Tween Bridge Solar Farm

9.2 Statement of Common Ground with City of Doncaster Council

Document Reference: 9.2

Revision 3

Zones of Impact are subject to refinement following detailed design, the figure presents a worst-case scenario on the basis of current understanding

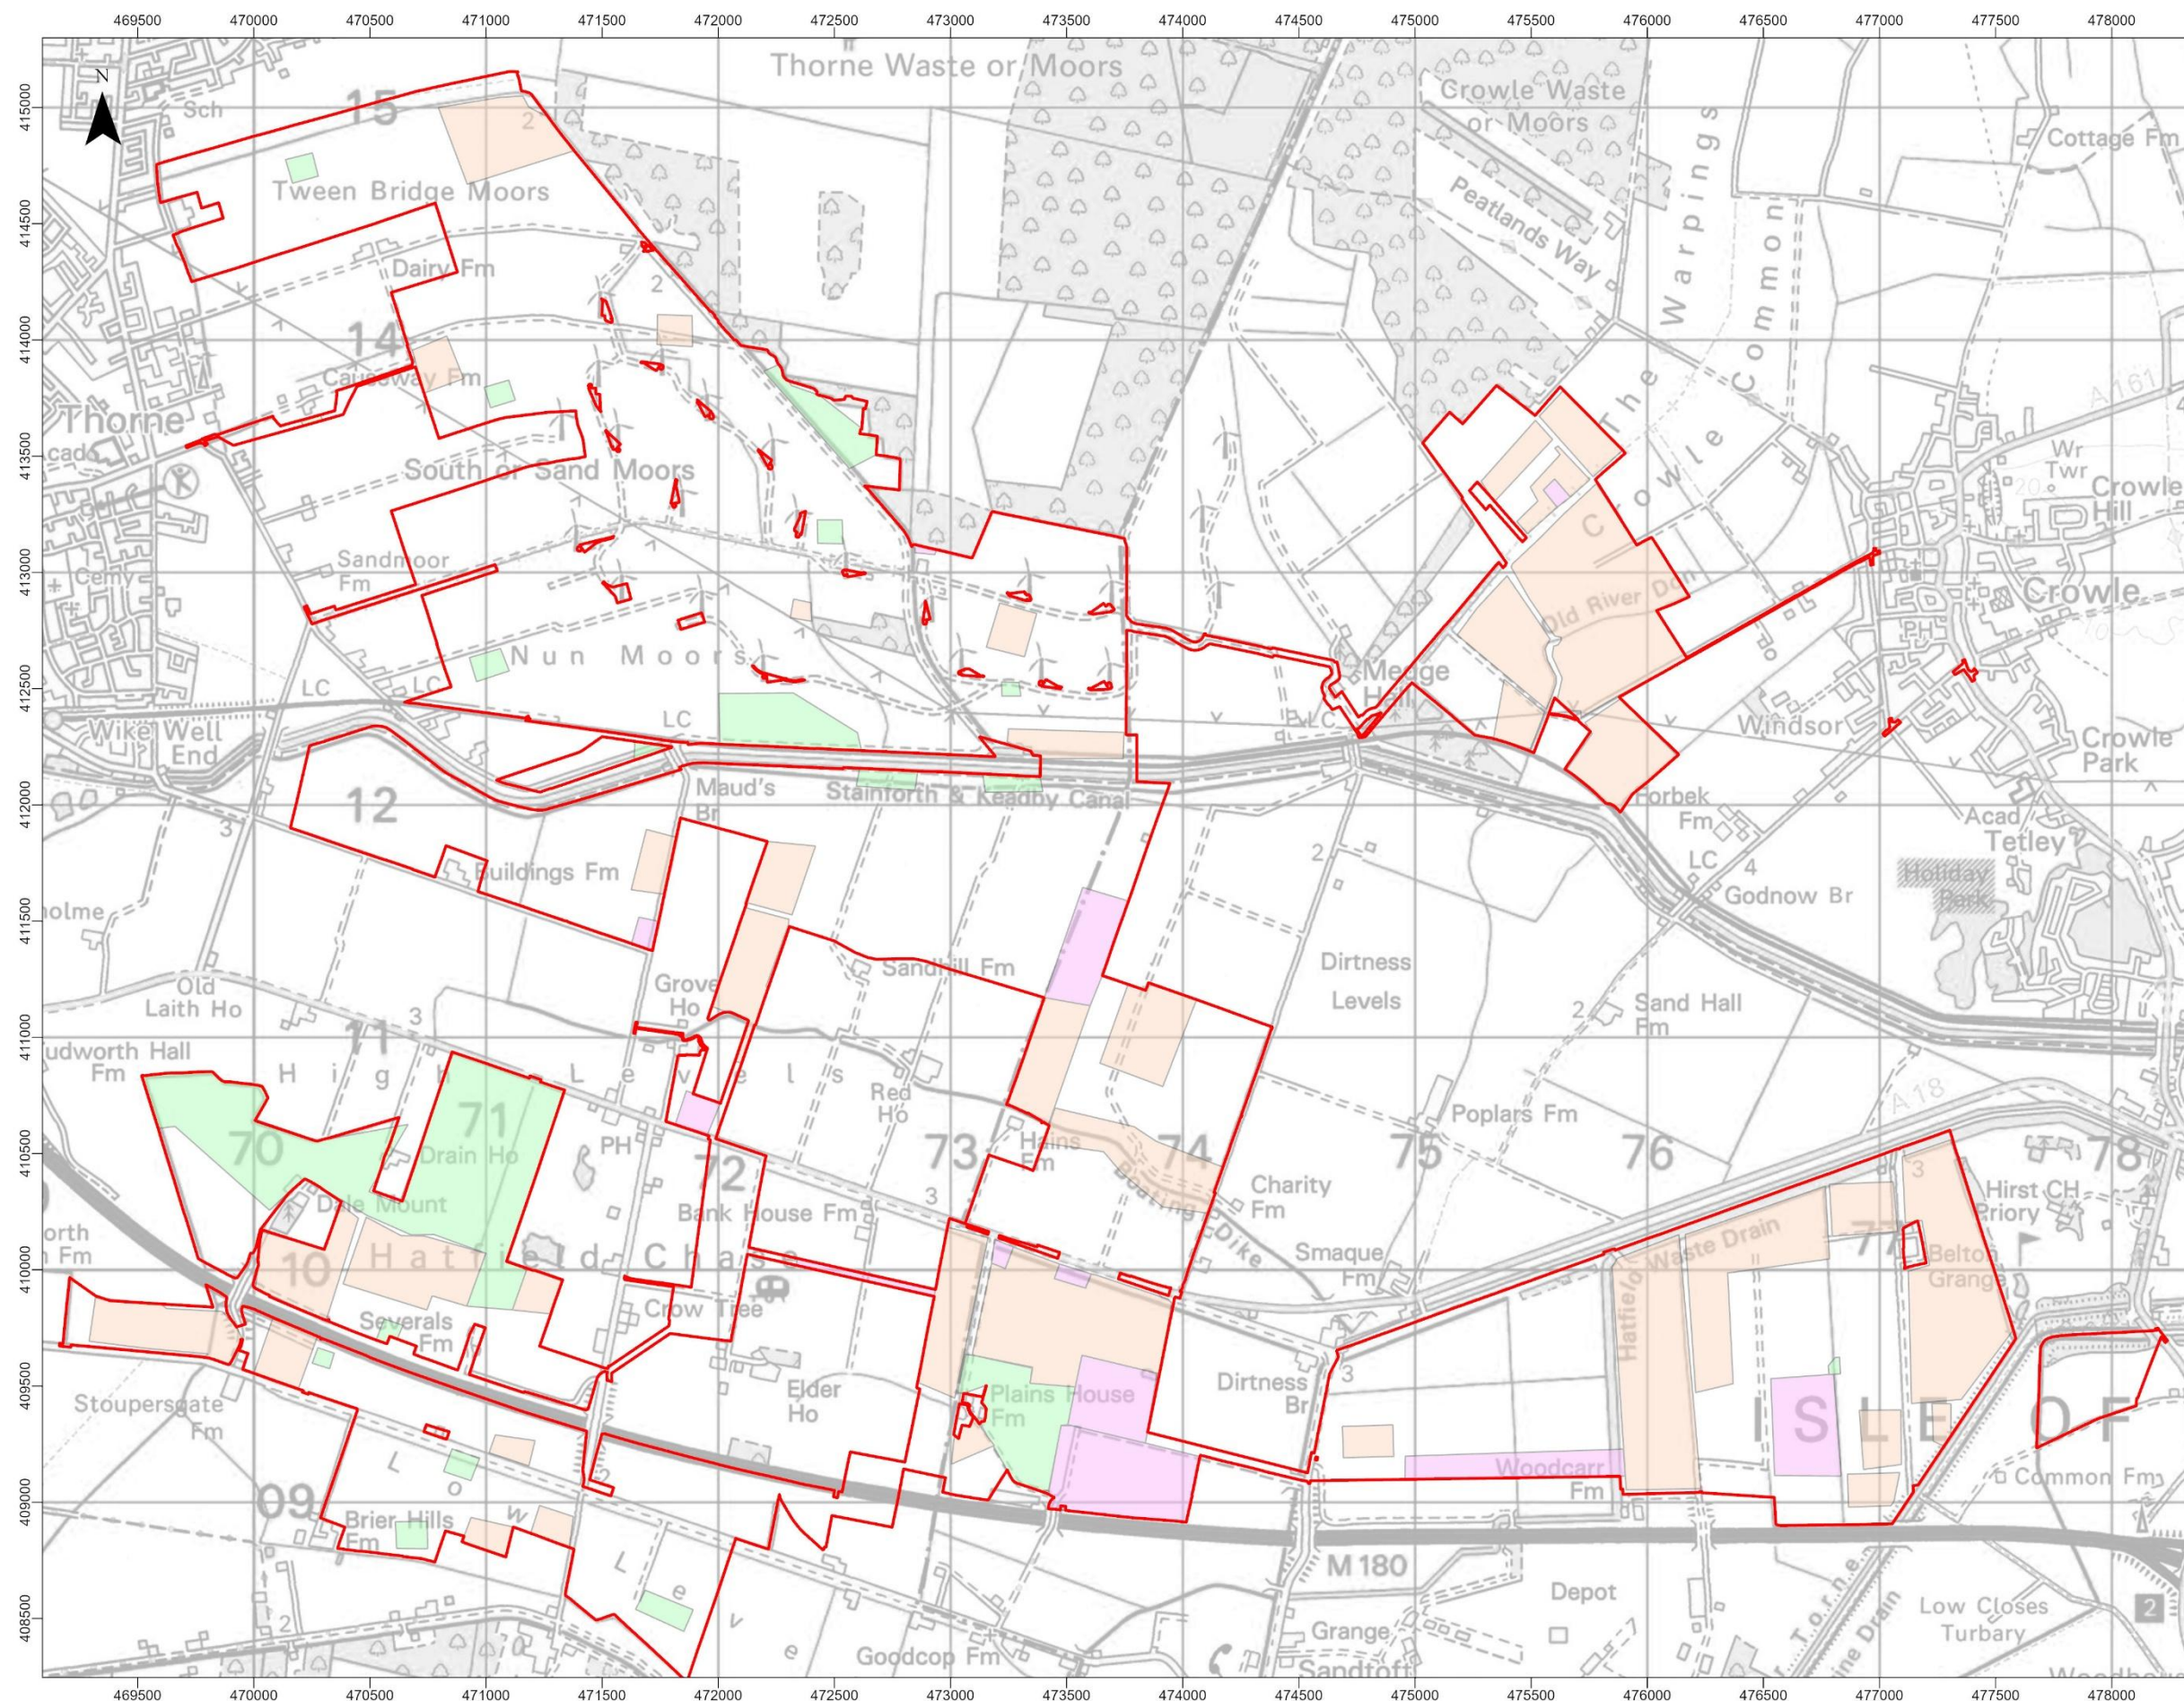
Ref	Topic	City of Doncaster Council Position	Applicant Position	Status
			It is the case that a full suite of evaluation has taken place to inform the assessment of the Scheme.	
		Paragraph 8.18 of RR This archaeological mitigation strategy is actually an archaeological evaluation and mitigation strategy that the applicants propose should be undertaken post consent. However, determining the impact of a proposed development upon potential archaeological remains is something that needs to be understood prior to determination so that appropriate planning weight can be afforded. To not do so could lead to harm to archaeological remains or inappropriate mitigation post-consent. Perhaps a useful compromise would be to evaluate the areas of high impact construction activities such as below ground cable routes, directional drilling access pits, temporary compounds, BESS and substations at this stage so that any issues could be addressed in a more timely fashion.	The approach to assessing potential impacts to the archaeological resource within ES Volume 2 Chapter 8: Cultural Heritage and Archaeology [Document Reference 6.2.8 Revision 3] has been precautionary with a worst-case scenario employed to ensure adverse effects are clearly articulated and due weight given to these. The exact routes and construction details for the higher impact elements of the Scheme would be developed as part of the detailed design of the Scheme and secured by requirement, notably requirement 6 of the Draft Development Consent Order [Document Reference 3.1 Revision 7]. The Applicant is confident that any potential evaluation or mitigation required within these areas can be delivered in a timely fashion post-consent. The Outline AMS [Document Reference 6.3.8.6 Revision 3] has been amended to	Not Agreed

Ref	Topic	City of Doncaster Council Position	Applicant Position	Status
			include a zoning plan following comments received from SYAS on behalf of CDC.	
9		Paragraph 8.19 – 8.20 of RR Where the oAMS specifies mitigation measures rather than evaluation techniques, SYAS is broadly in agreement with the proposals. Micro-siting should be added to the options specified in paragraph 5.10 as another method of avoiding archaeological impacts. As we were not given the opportunity to review the strategy before submission, there are a number of minor revisions that should be added: • Details arrangements for monitoring the fieldwork by local authorities should be included • The oAMS should use the language of the DCO stating in paragraph 5.11 that site specific WSIs “will be substantially in accordance with this strategy”	The Applicant acknowledges the broad agreement. The Applicant has considered the comments provided and will continue to engage on the ES Technical Appendix 8.6 Outline Archaeological Mitigation Strategy [Document Reference 6.3.8.6 Revision 3] to ensure the approaches detailed are acceptable to the City of Doncaster Council. The Applicant has prepared a revised Outline Archaeological Mitigation Strategy [Document Reference 6.3.8.6 Revision 3]. Requirement 12 of the Draft Development Consent Order [Document Reference 3.1 Revision 7] secures the Outline AMS by stipulating that the written scheme of investigation for each development phase must be substantially in accordance with the Outline AMS. Requirement 12 also provides approval rights to the relevant local planning	Agreed
